DRB CASE ACTION LOG (PREL/FINAL)

DRB Application No.: 08DRB-70470

Project # 1007312

SUBJECT: Project # 1007312, 08DRB-70254 Sketch Plat Review and Comment, Lots 91, 92, 93, and 218-C-A, Located on 2nd St. SW and Woodward Rd. SW.

# PLAT OF TRACT 1 SECOND STREET STUDIOS

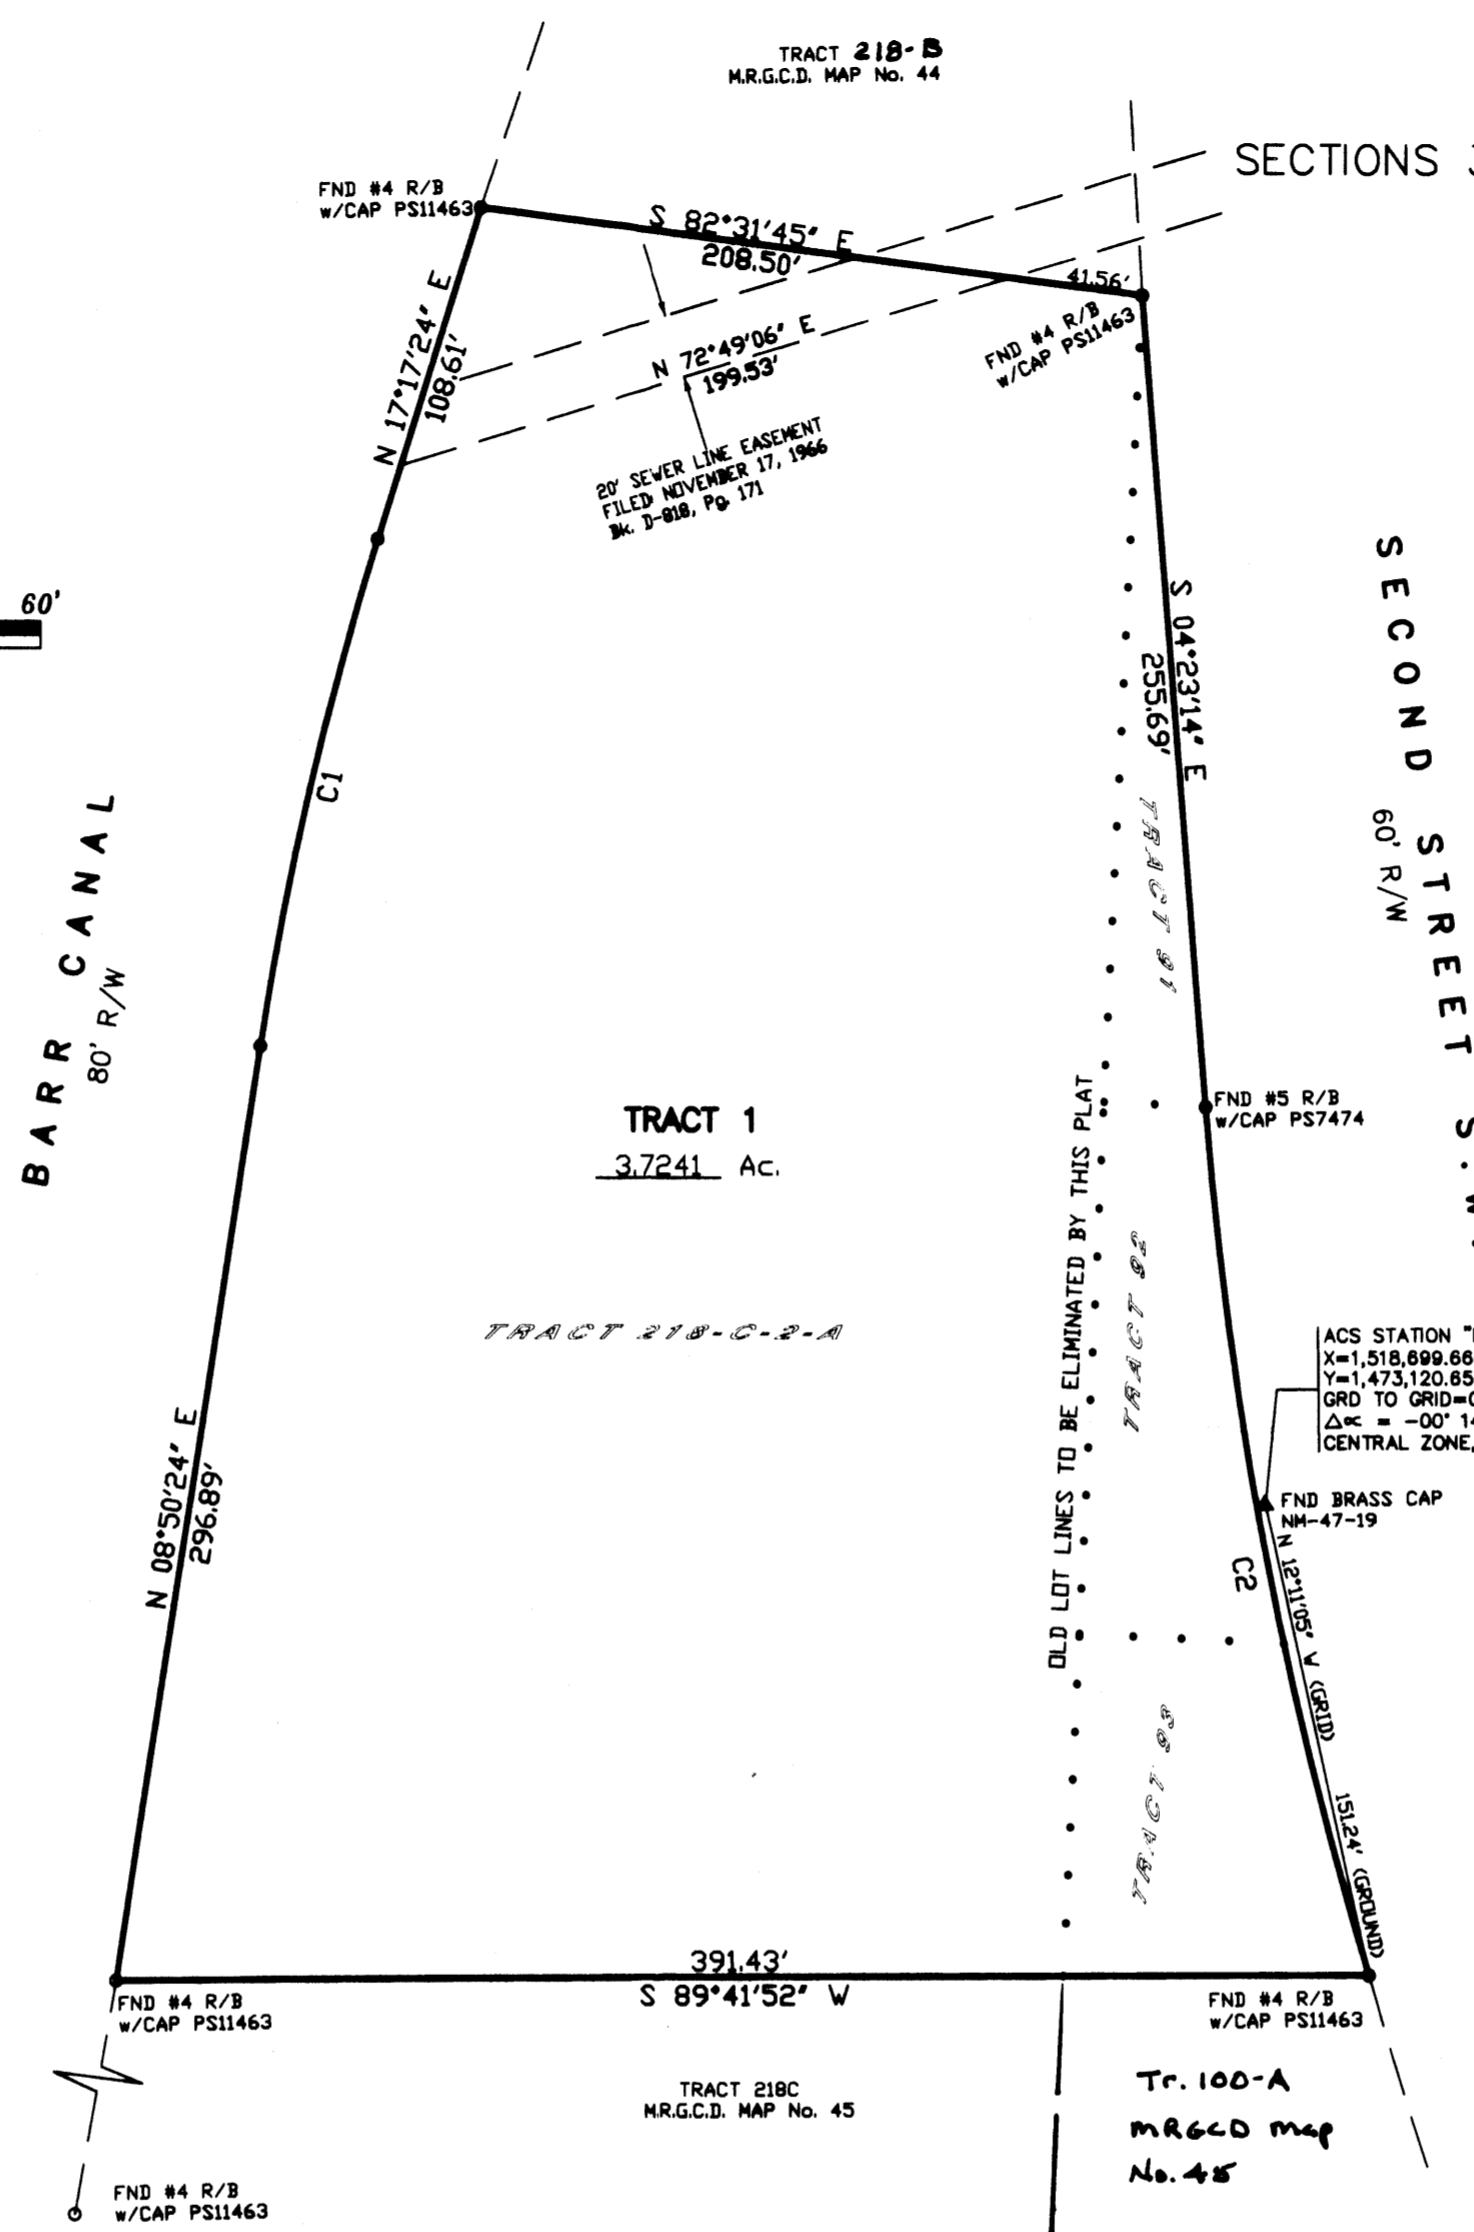
UTILITIES: - add/grant 20 ft easement

PLANNING (Last to sign): - AMAFCA signature
- owner initials
